Engineers Comments Regarding Surface Water Drainage

Application Reference:	R/239/24/PL	Reviewer Reference:	ADC/SB
Planning Officer:	Harry Chalk	Date of Review:	10/04/2025
Site Name:	Condair Building Artex Avenue Rustington BN16 3LN		
Application Description:	Demolition of existing building (facing Brookside Avenue) and redevelopment of the rear of the site for office use, with ancillary storage facilities and landscaping falling within Class E. This application is in CIL Zone 4 and is zero rated as other development.		
Assessment Number:	1 of 2

Drawing Title
Existing Drainage

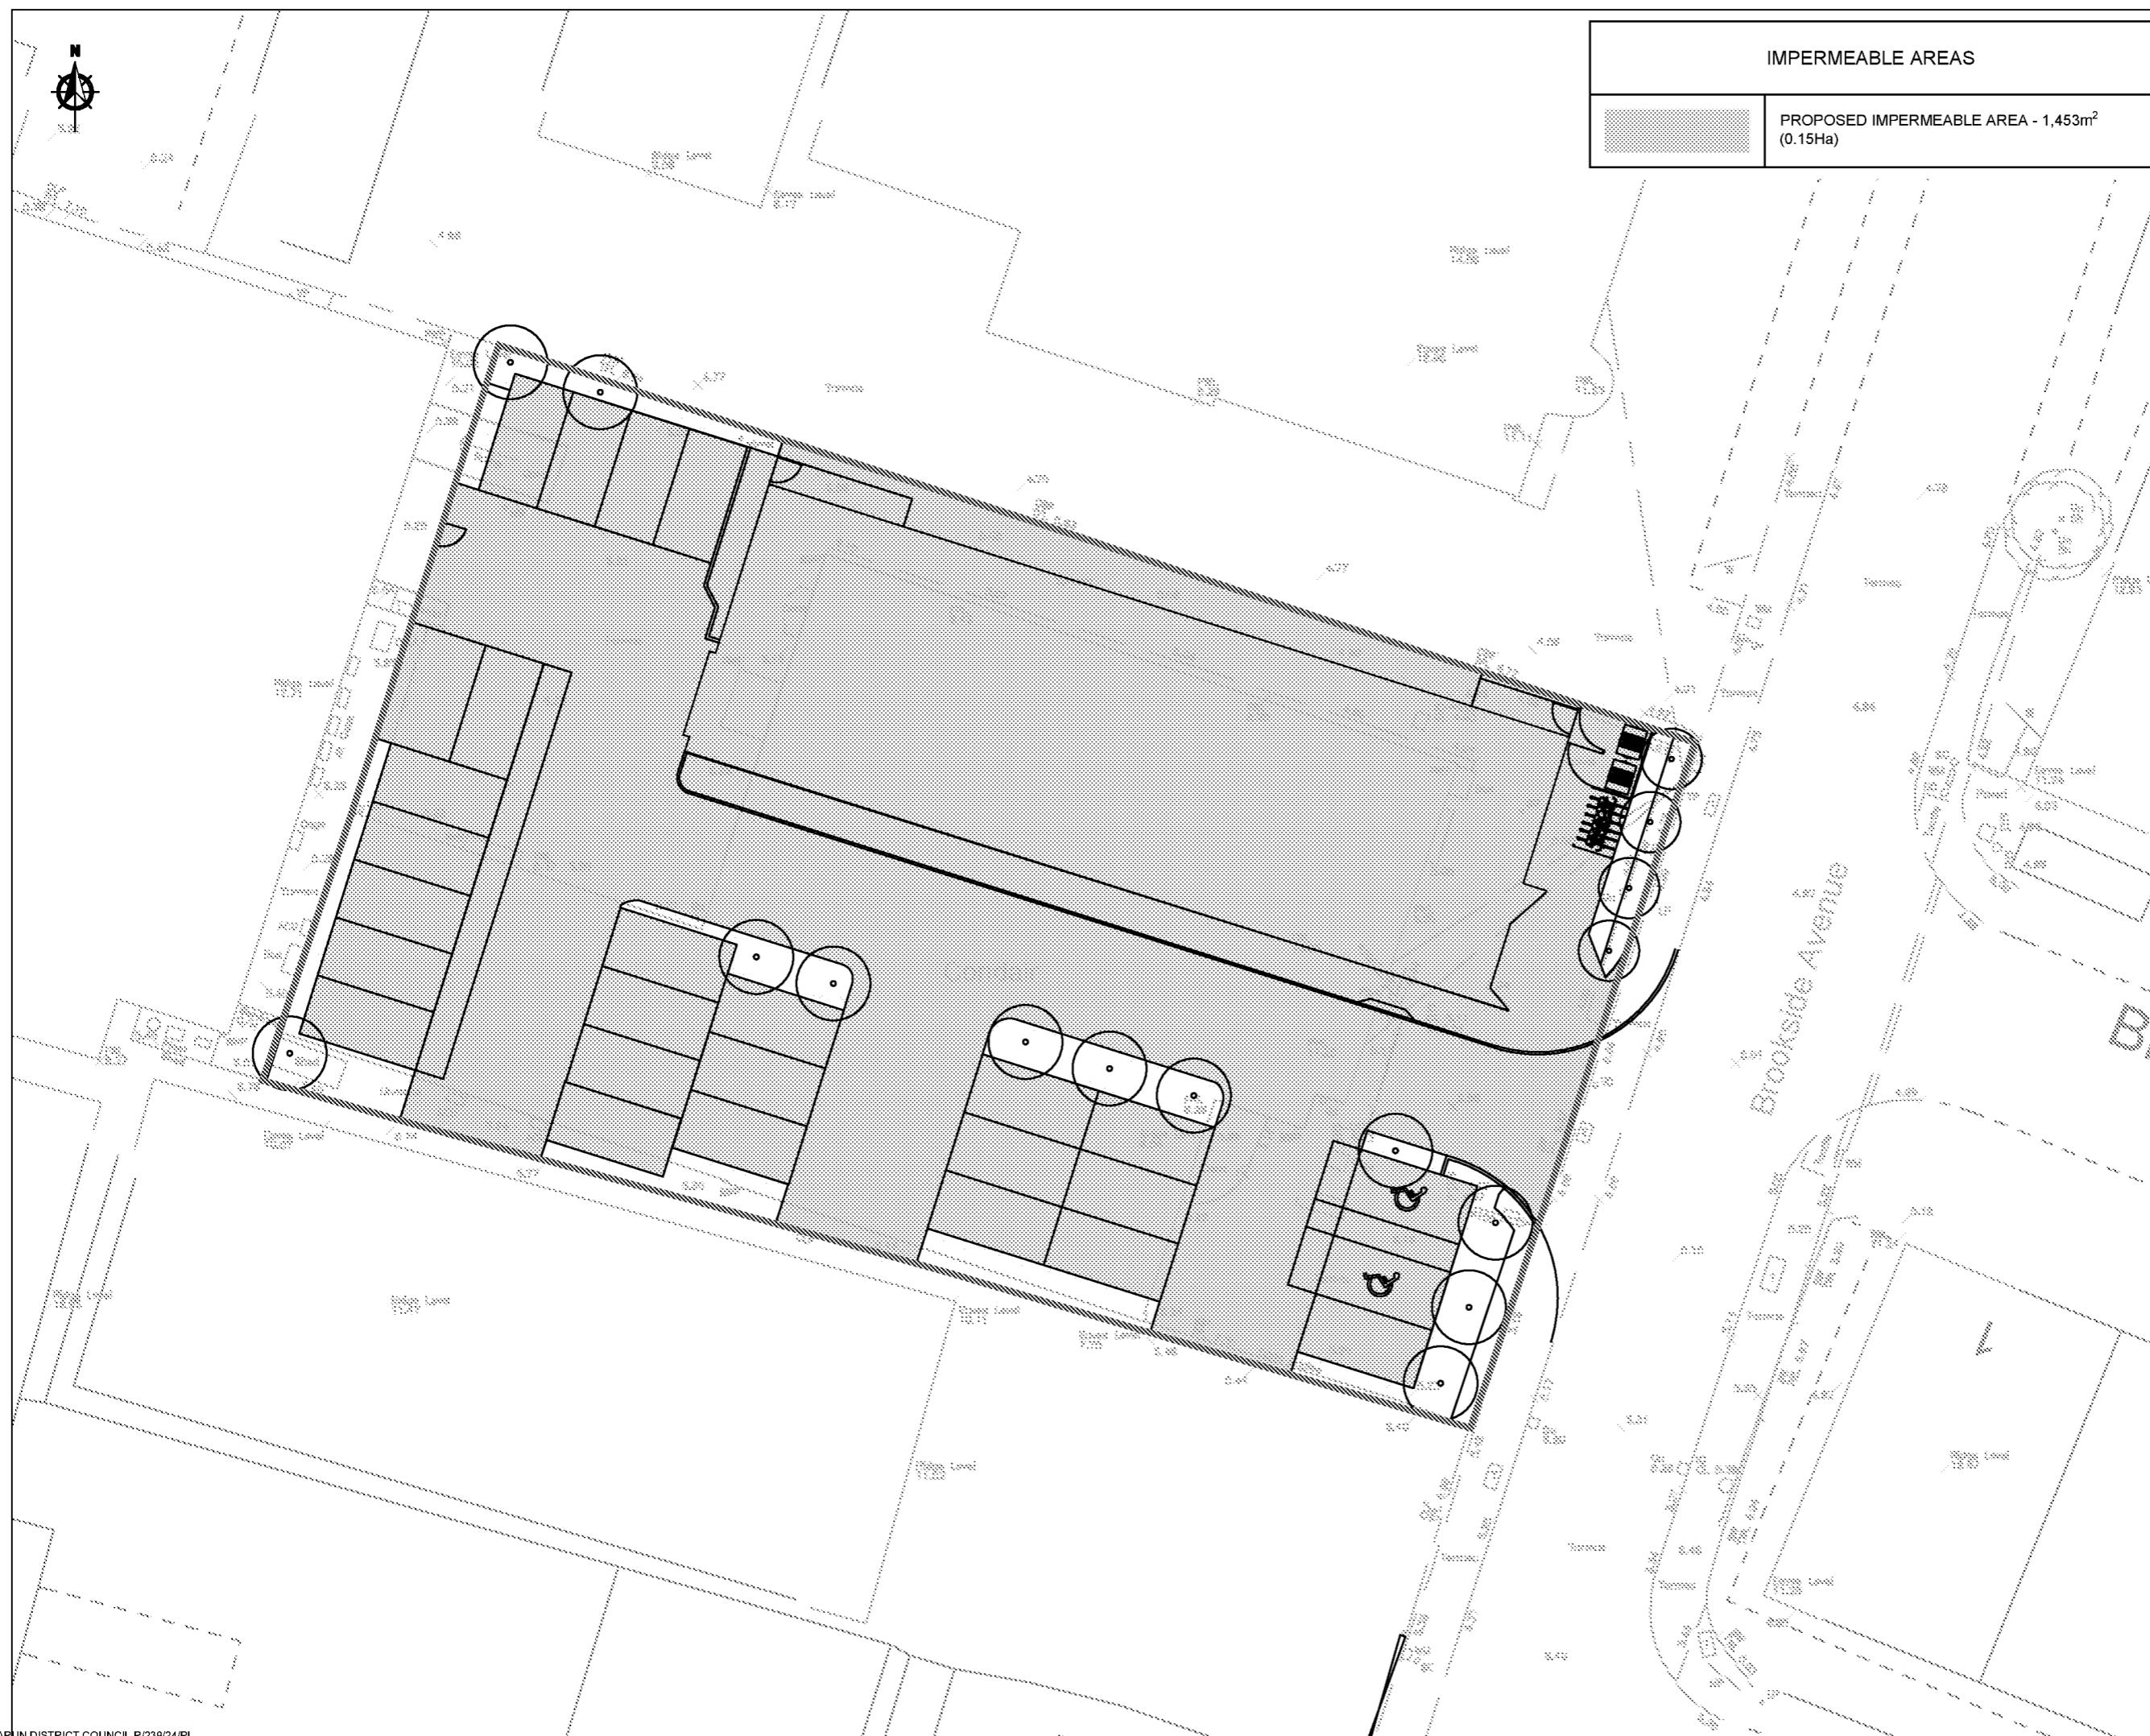
The site apparently disposes of surface water to the public foul sewer, evidence of this has not been fully submitted, although it is not disputed at this stage. Additional surface water is said to flow overland towards the highway where it discharges informally to the highway drainage network via road gullies. Evidencing this informal connection will be critical in agreeing a formal connection with the asset owner, West Sussex County Council.

Existing site drainage features are investigated – condition, performance, and ownership.

Evidence not submitted.
